Description: Single dwelling and garage

Location: The Broadway
Crawford Gardens
Crowland

Amendment: Revised front and side elevations
Dwg. No. VAR21/205 Rev B

NOTICE OF ACCEPTANCE OF AMENDMENT

AMENDED PLAN

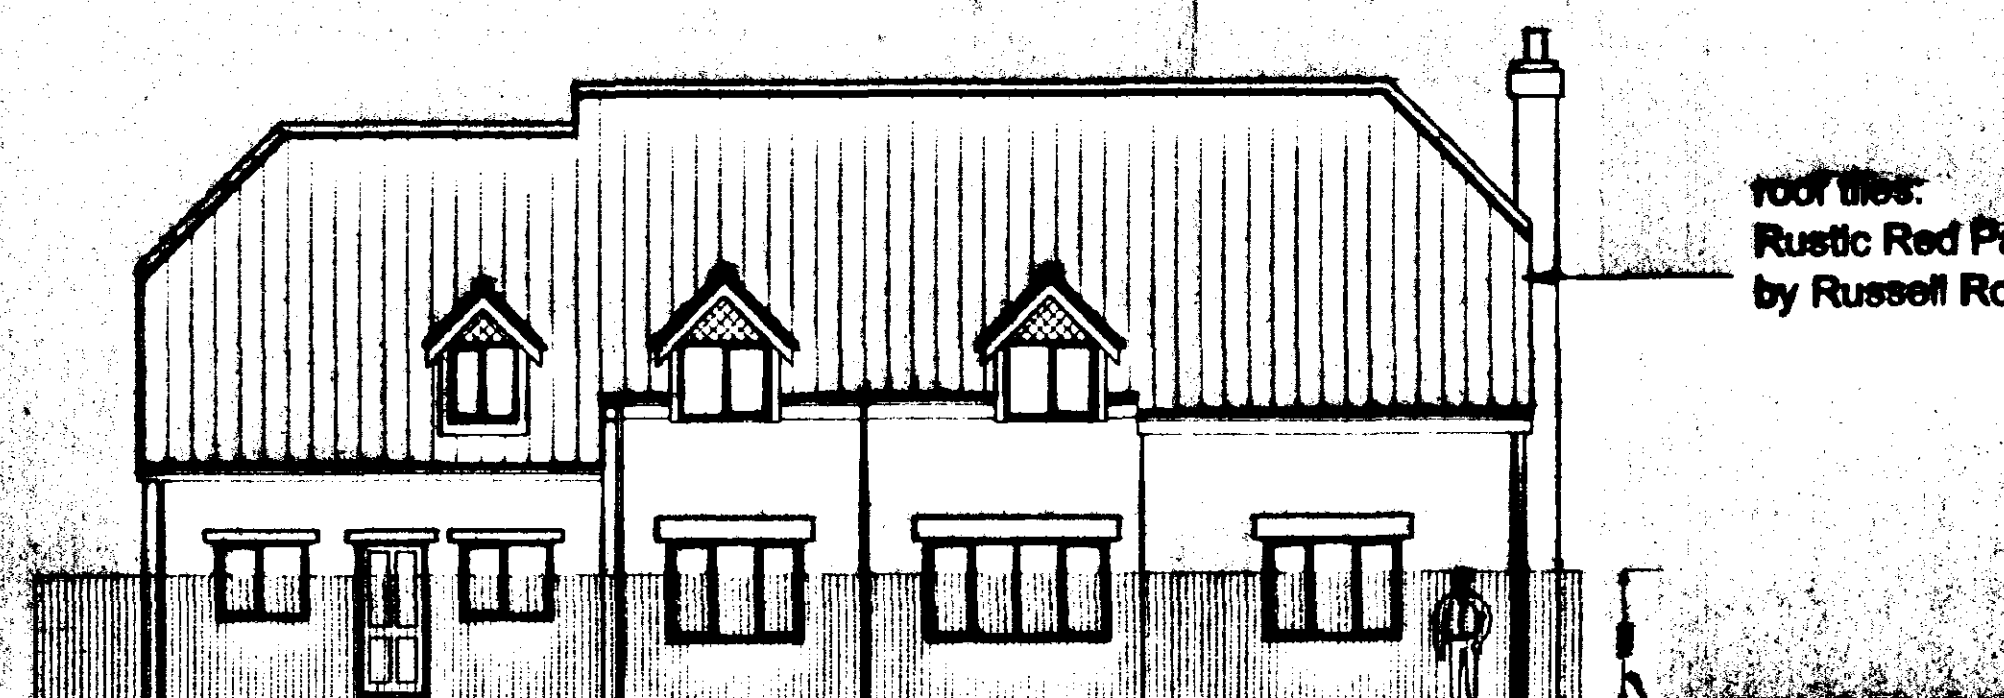
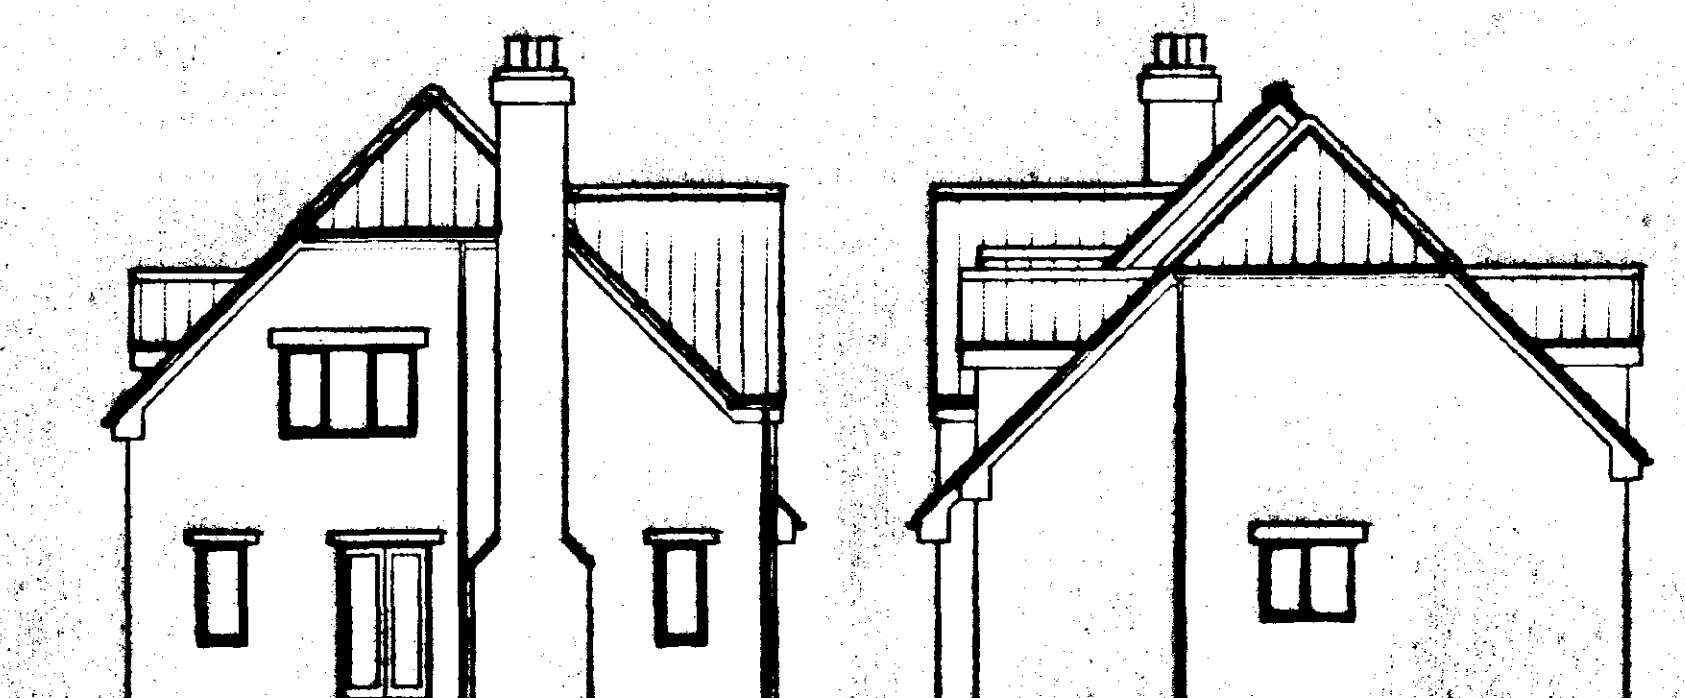
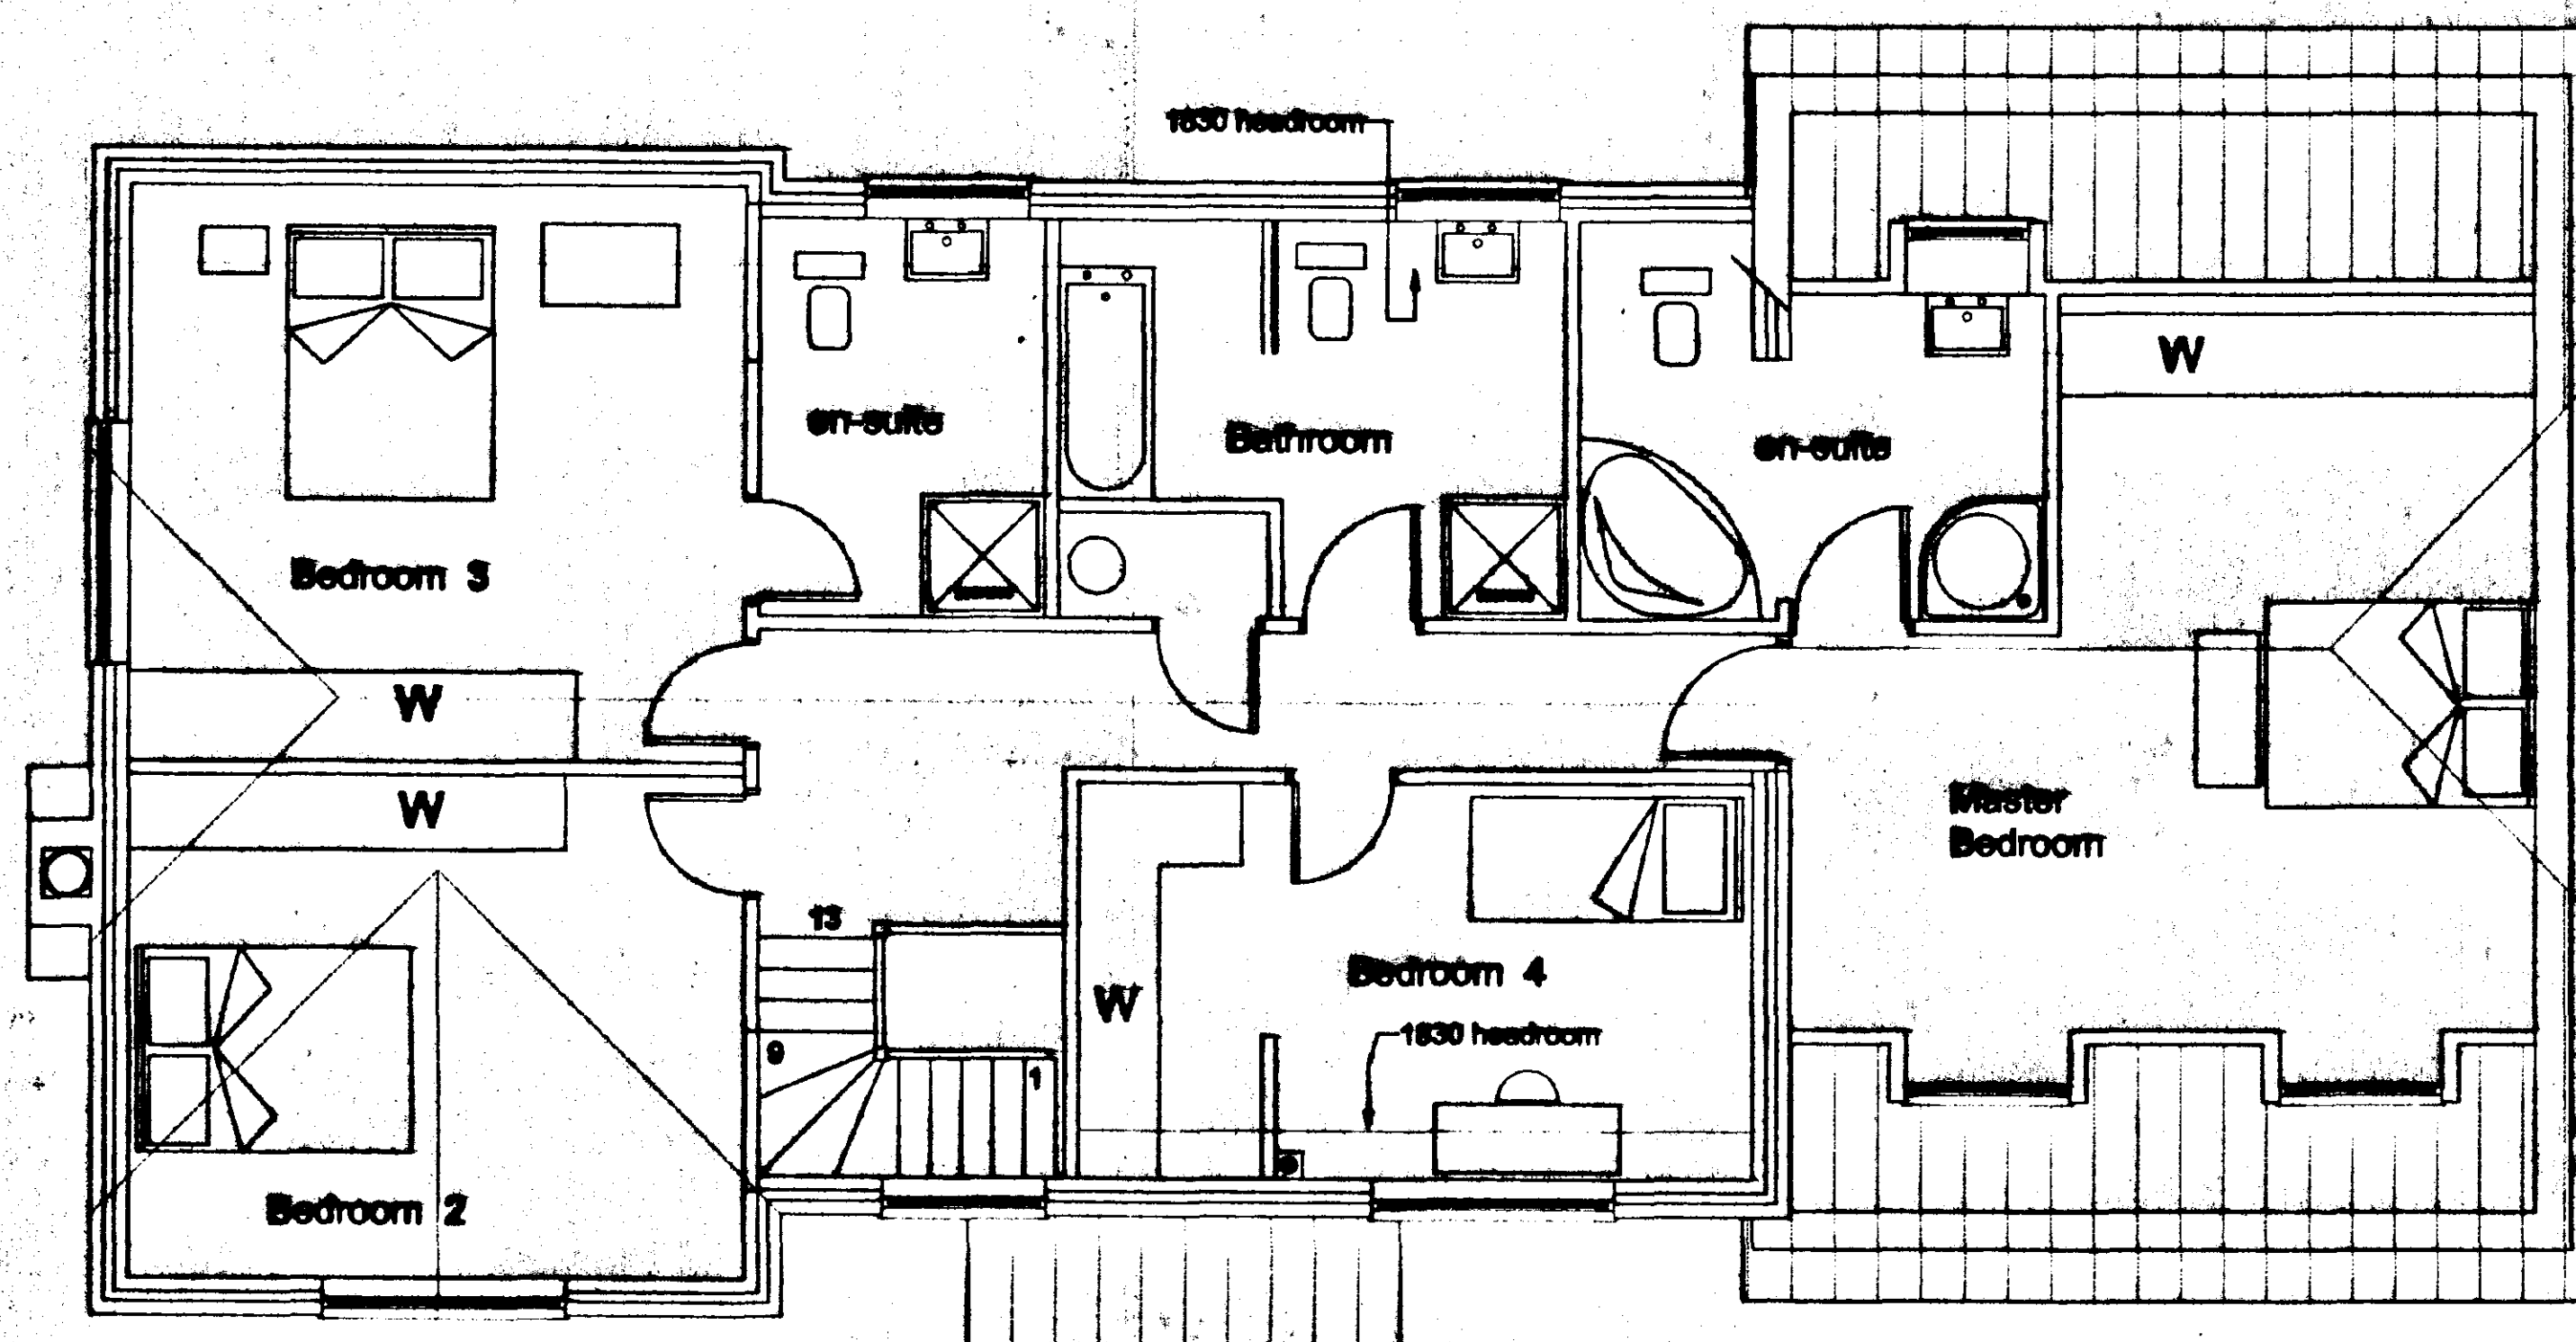
As can be seen, we have revised the front and side elevations to show a full eaves height to the main part of the house whilst maintaining the dormer appearance over the garage. The ridge height remains as before.

The amended details submitted in respect of the above proposal have now been considered and there are no objections to the amendment being implemented to the extent described above.
